## DRB Comments Response

January 3, 2023  
City of Albuquerque  
Development Review Board

Re: **DRB Comments for PR-2022-007664 / SI-2022-01770**  
**Luxelocker, Luxury Boat & R.V. Storage**  
**San Diego Avenue NE, Albuquerque, NM 87113**

SHEET NUMBER: **A-1.0**

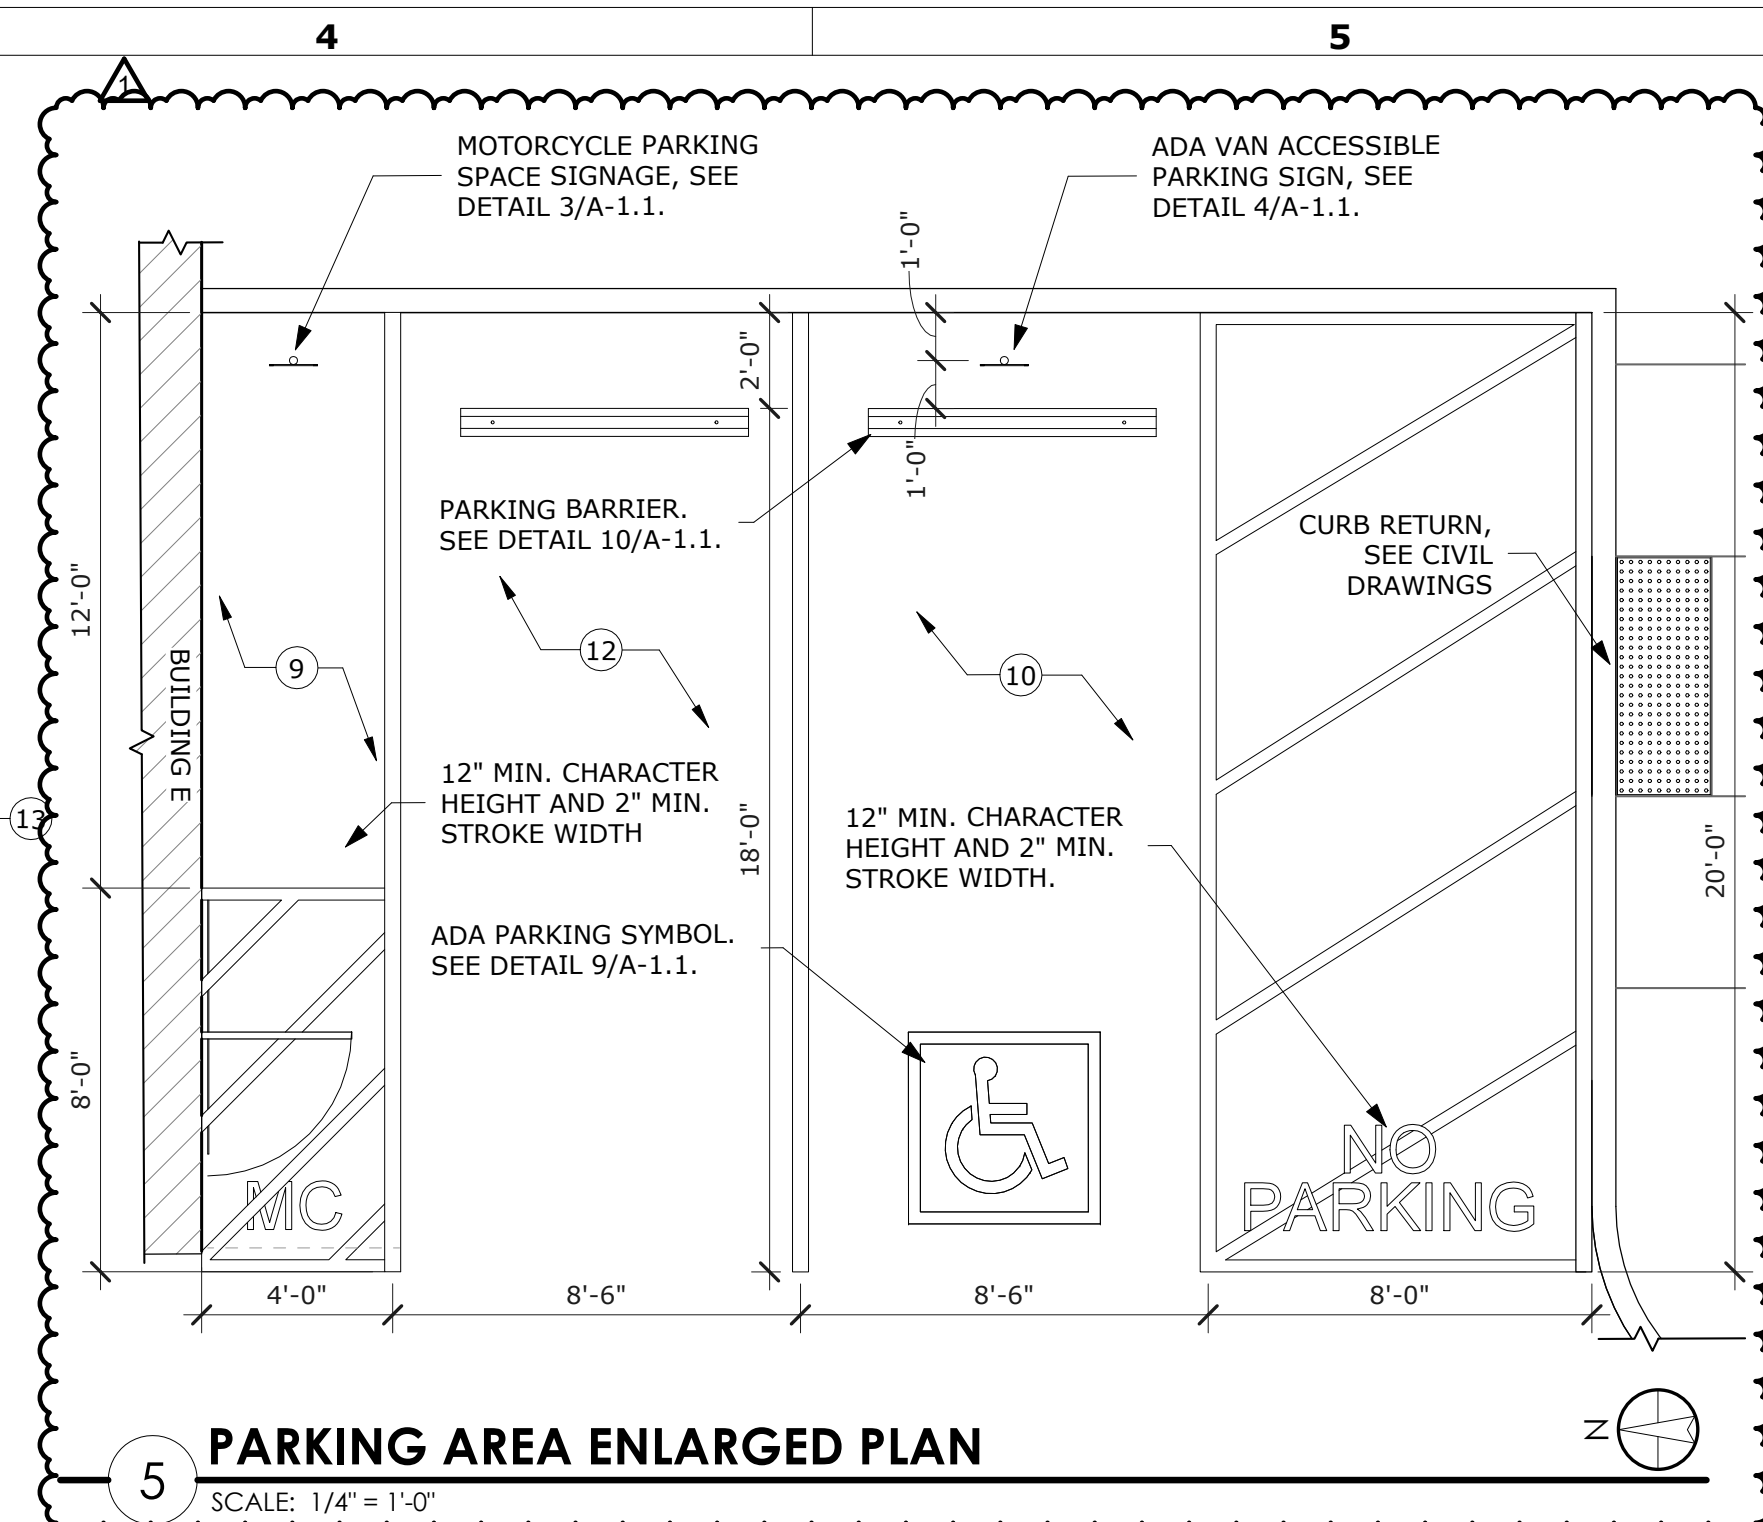
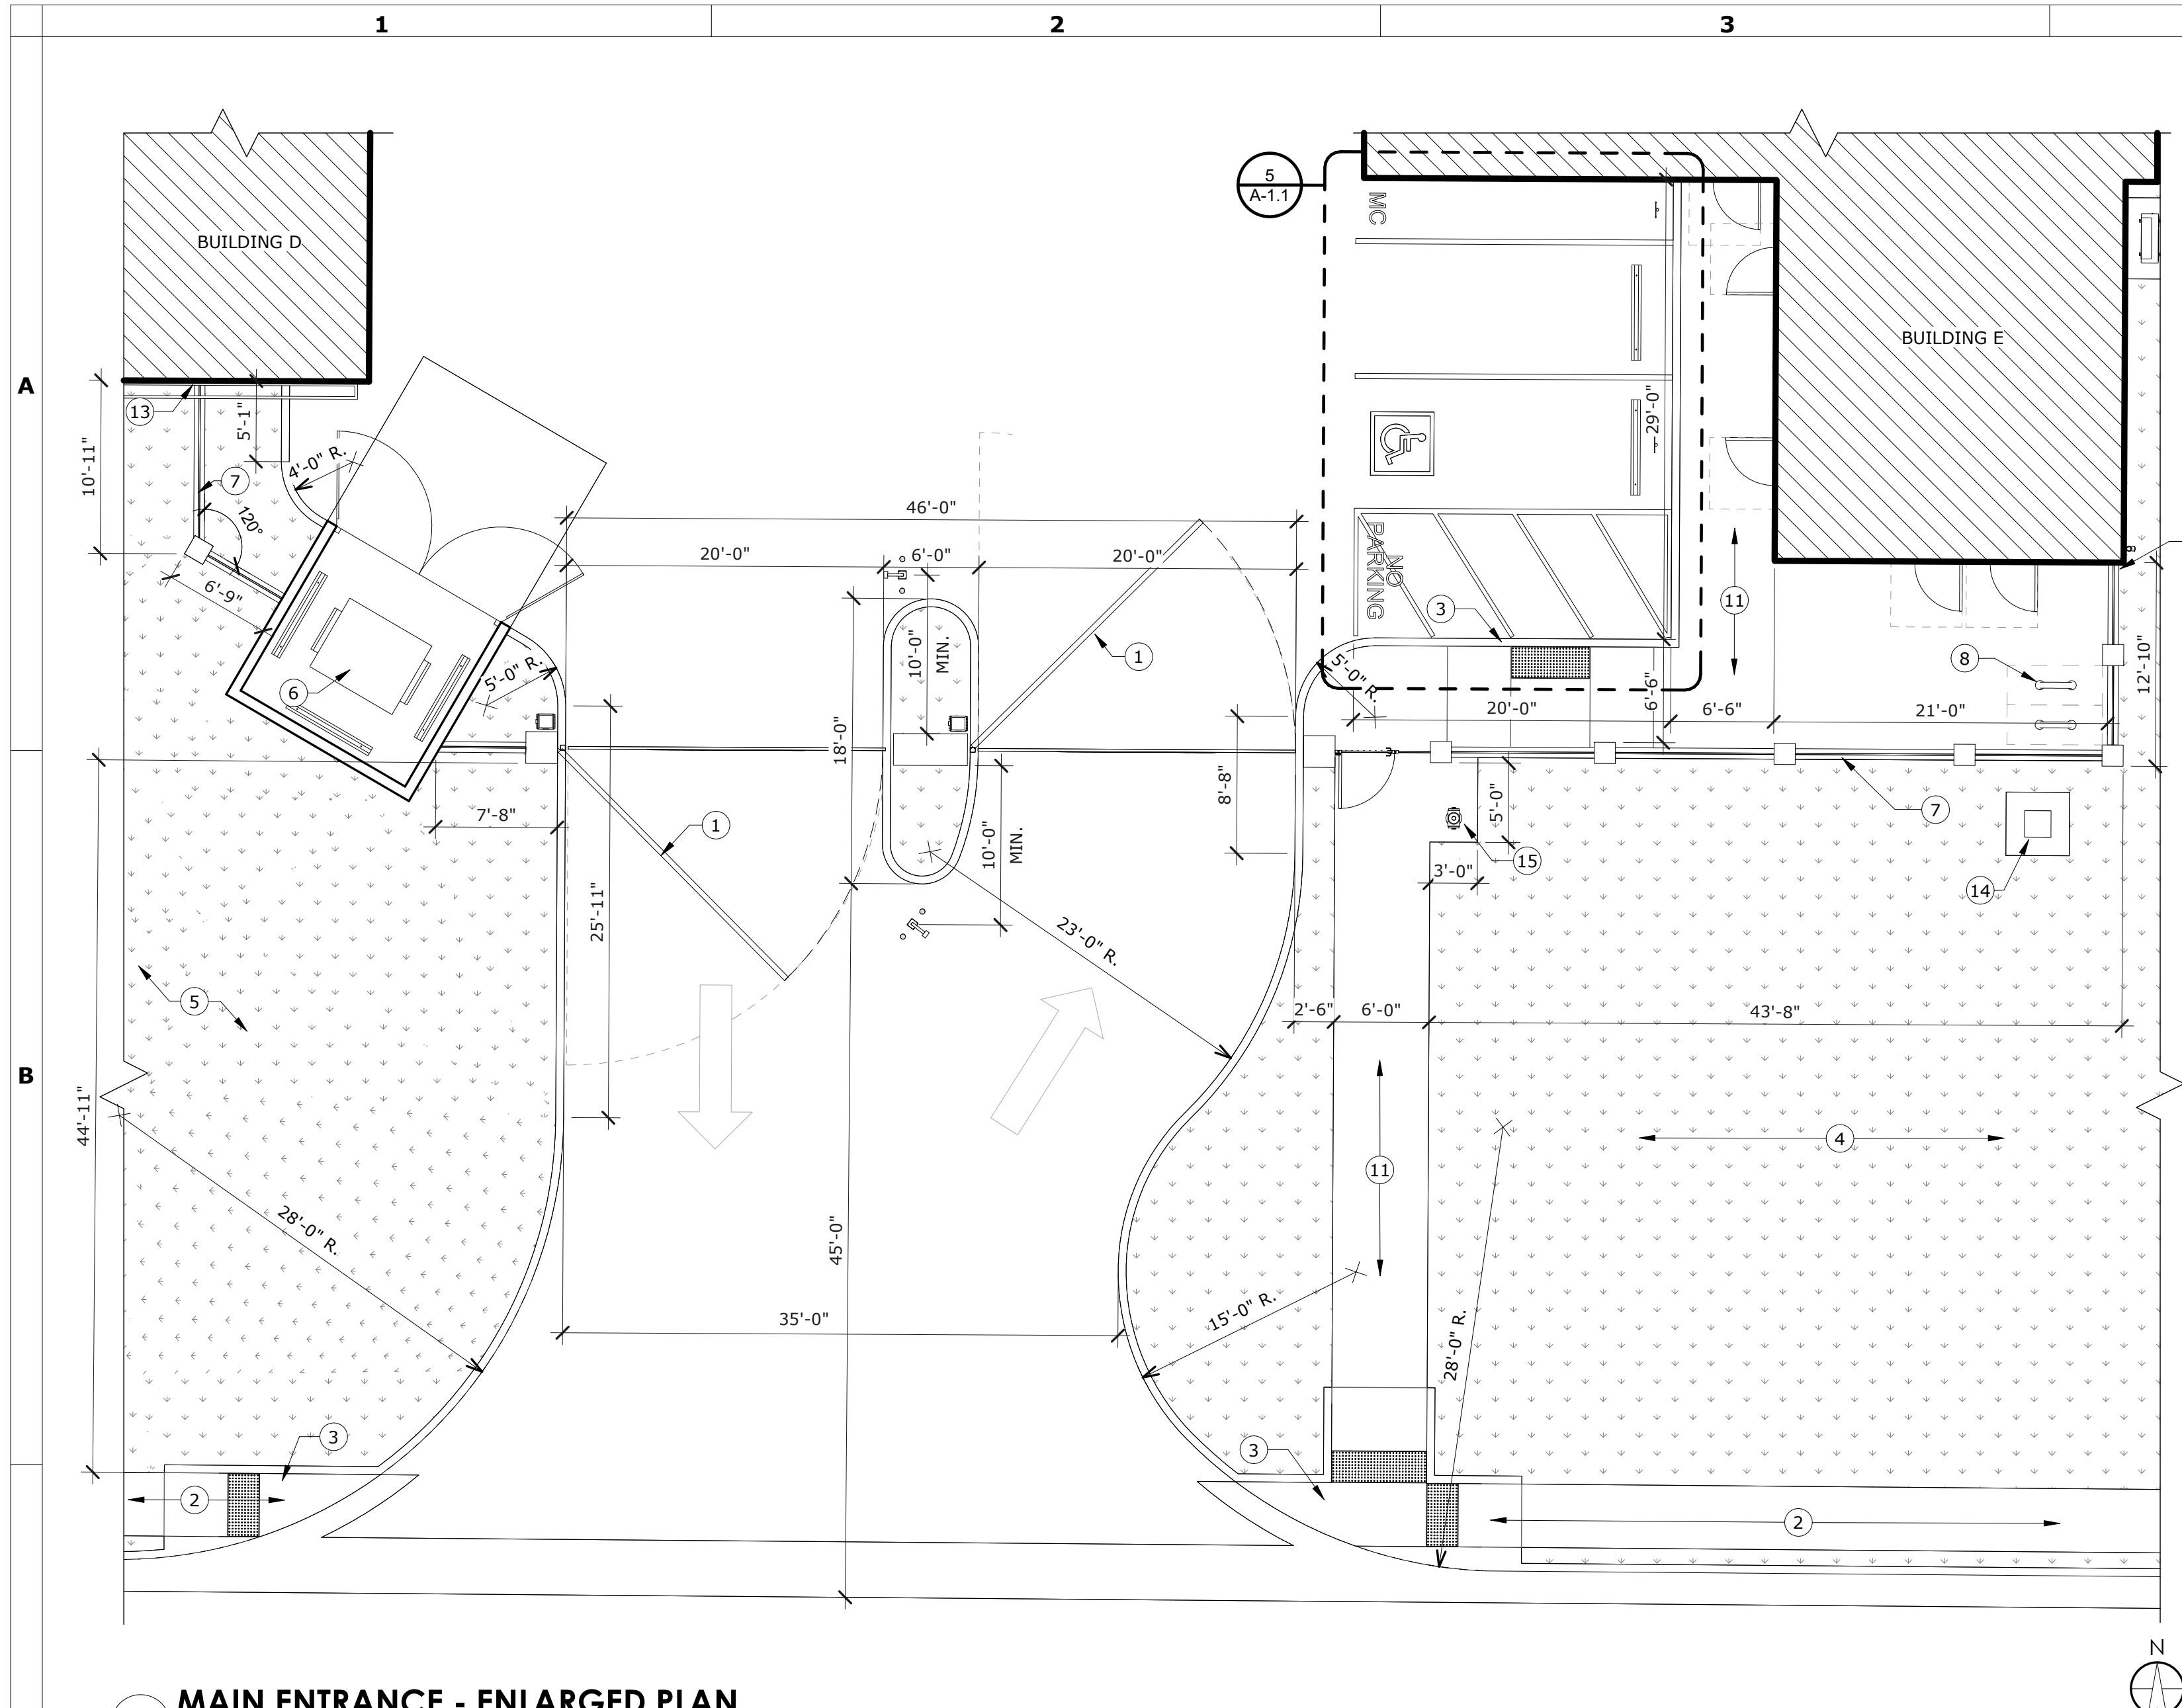
**R2. Signature blocks for the DRB signatures has been added to sheet C0.**  
Updated 12.6.22: The signature blocks for the DRB signatures must be added onto the Site Plan Amendment itself, for example, onto Sheet A-1.0.

**R3. Landscape plans have now been sealed and signed by a registered Landscape Architect in the State of New Mexico.**  
Updated 12.6.22: The Landscape Plan sheets were sealed and signed by a Landscape Architect registered in the State of New Mexico, and the remaining Site Plan sheets were sealed and signed by a design professional licensed in the State of New Mexico except for Sheet A-1.0. Sheet A-1.0 must be sealed and signed as well.

**R2. Please see the signature block has been added to sheet A-1.0.**
3. The Landscape Plan is sealed and signed by an Architect. However, Landscape Plans must be sealed and signed by a Landscape Architect registered in the State of New Mexico.

**R3. Please see signed and sealed sheet A-1.0.**

SHEET NUMBER
L-2.0

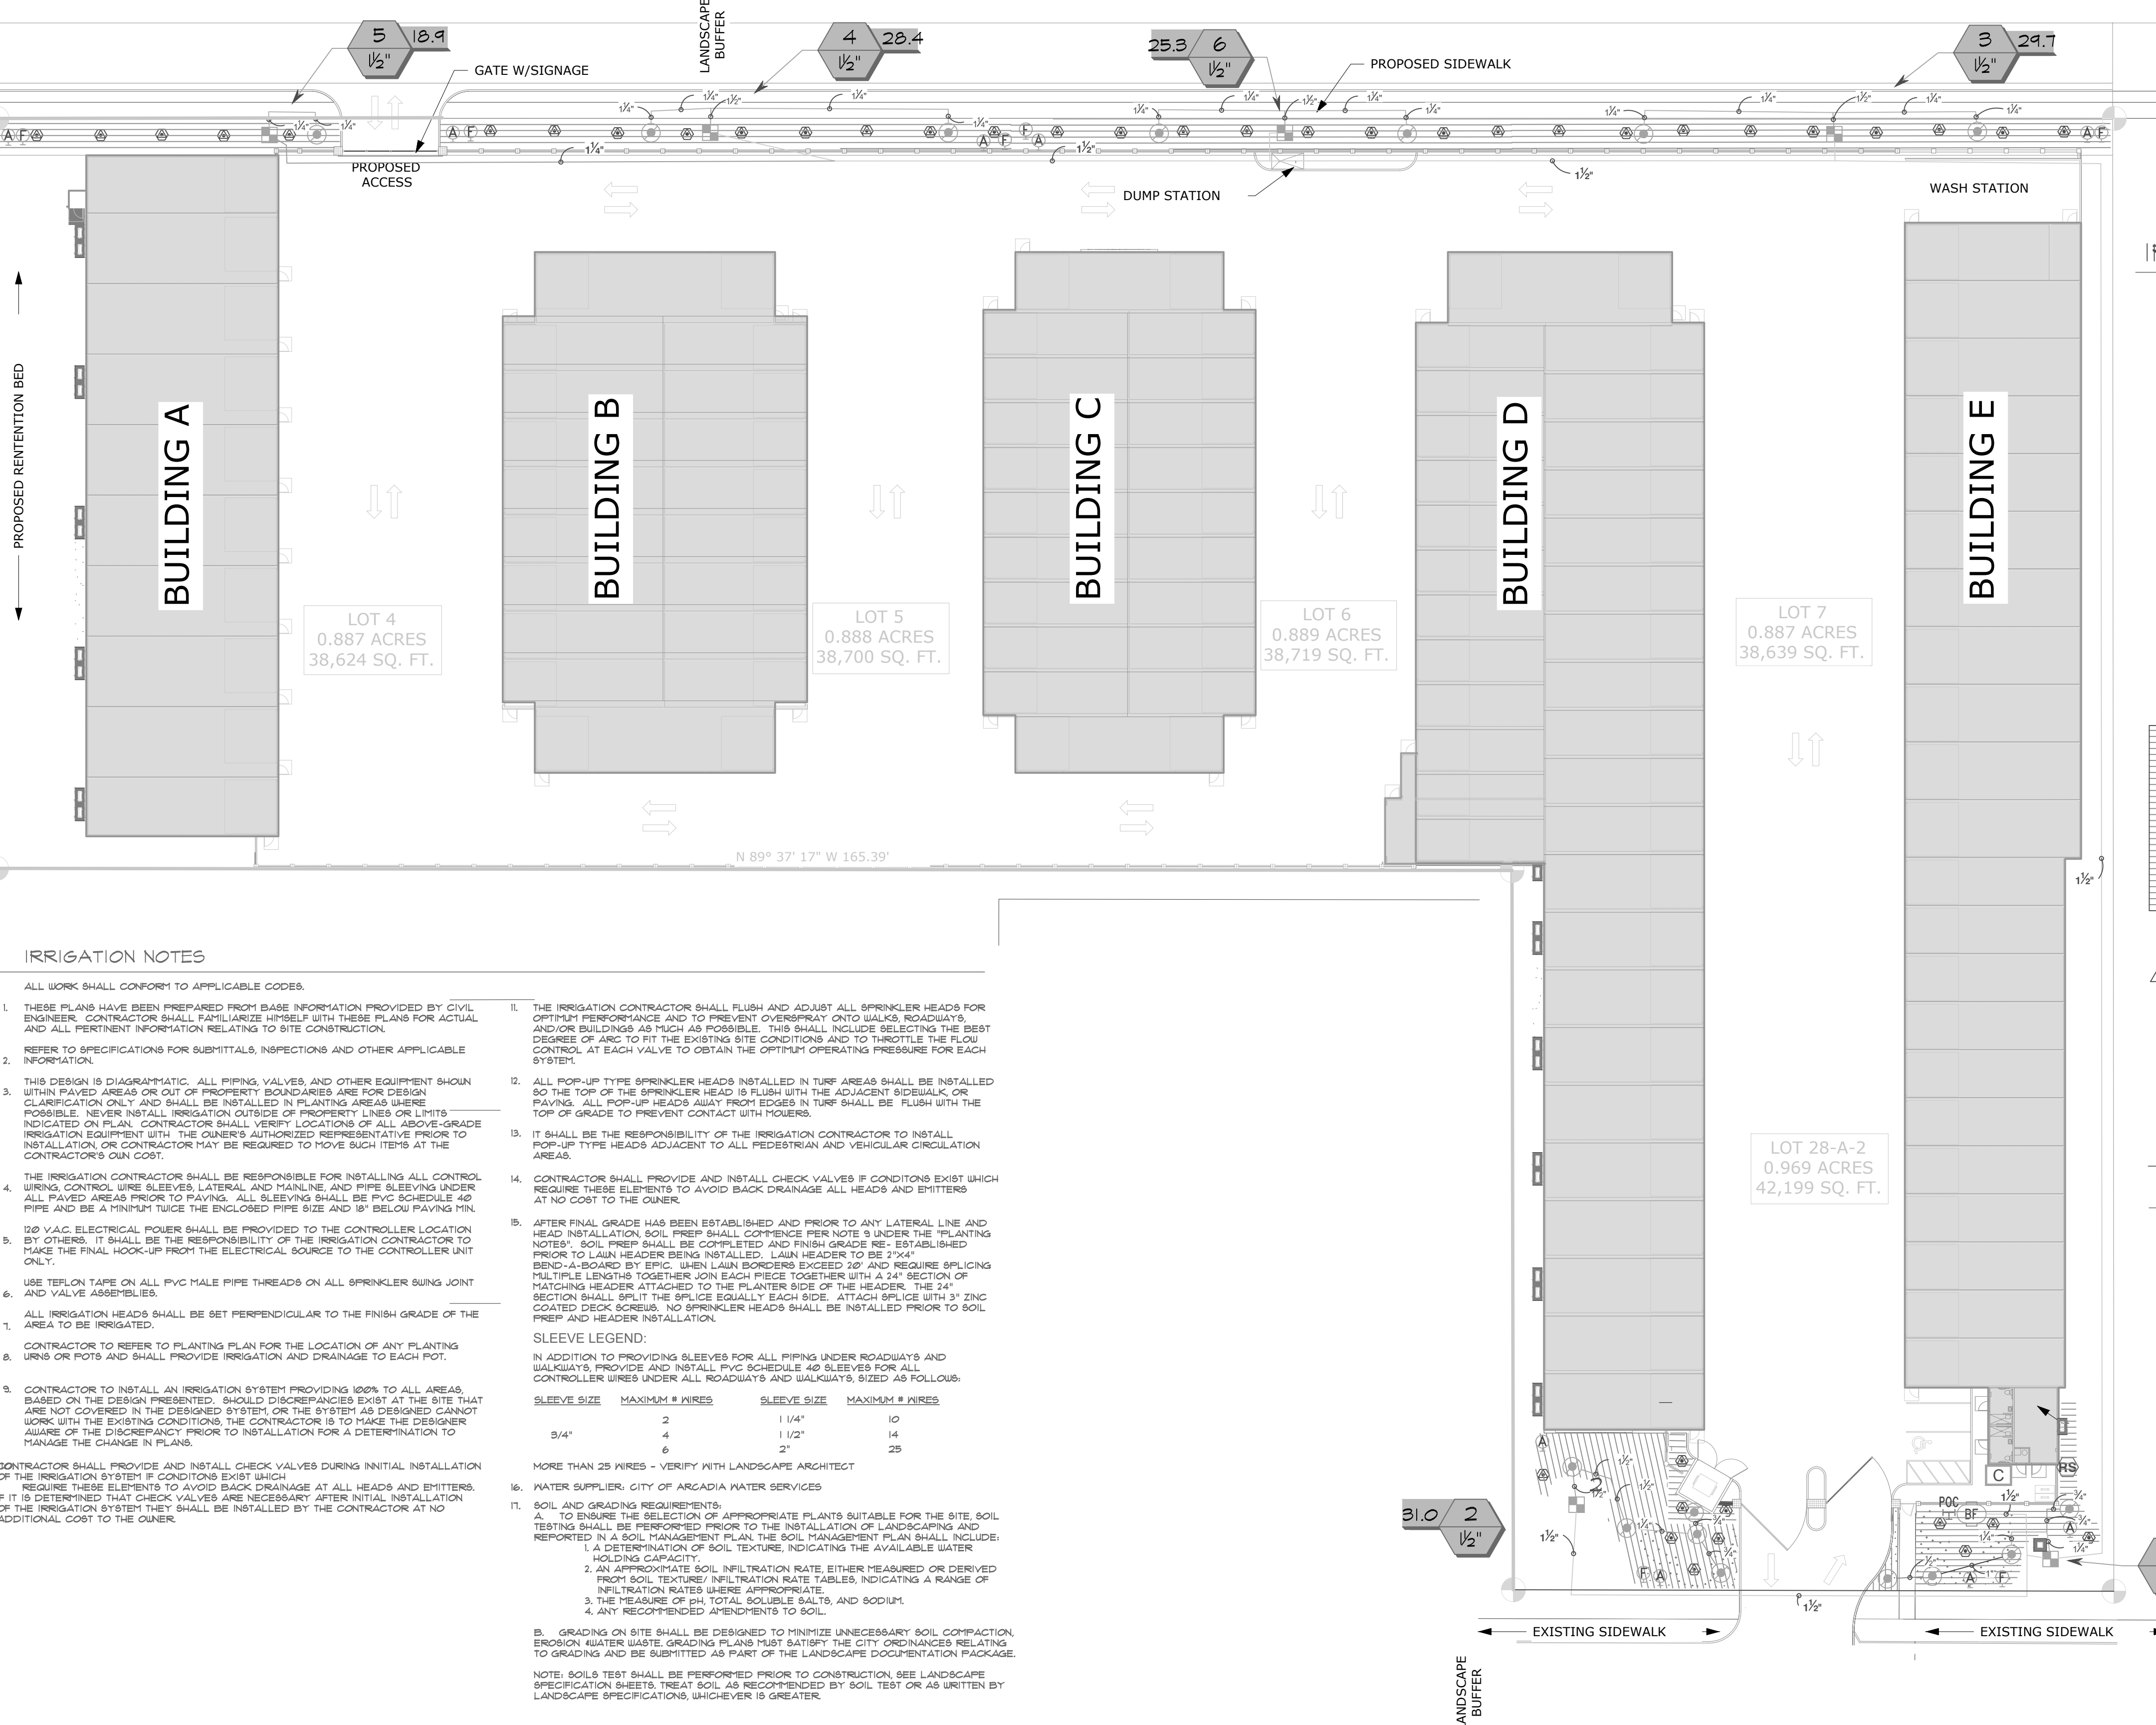
1. Development applicable per IDO 5-6(b), therefore street trees required and provided. Site Plan indicates landscape areas on side – what is intended for these areas? – please note. Please also indicate mulch materials. Organic mulch is required under trees per IDO Section 5-6(C)(5)(e); please add note if other mulches used.  
*Relevant Citations:*  
5-6(C)(5)(e) Organic mulch is required as ground cover under trees within a 5-foot radius around the tree trunk, but not directly against the trunk. In these areas, weed barrier fabric is prohibited.  
5-6(C)(5)(c) The use of gravel or crusher fines as ground cover is limited to a maximum of 75 percent of any landscaped area, or 50 percent in DT-UC-MS areas.

**R1.** *A note, added to sheet L-1.0, details the requirements of IDO 5-6(C) have been met.*  
Updated 12.07.22: Landscape notes state that all landscape areas are to receive a 2" layer of crushed rock throughout. Please revise the notes to add IDO citation 5-6(C)(5)(e) as stated above.

**R1.** *Landscape plans revised to show delineation of landscape materials.*  
Updated 12.21.21: No new submittal.  
**R1.** *Please see updated sheet L-1.0 with IDO citations added.*
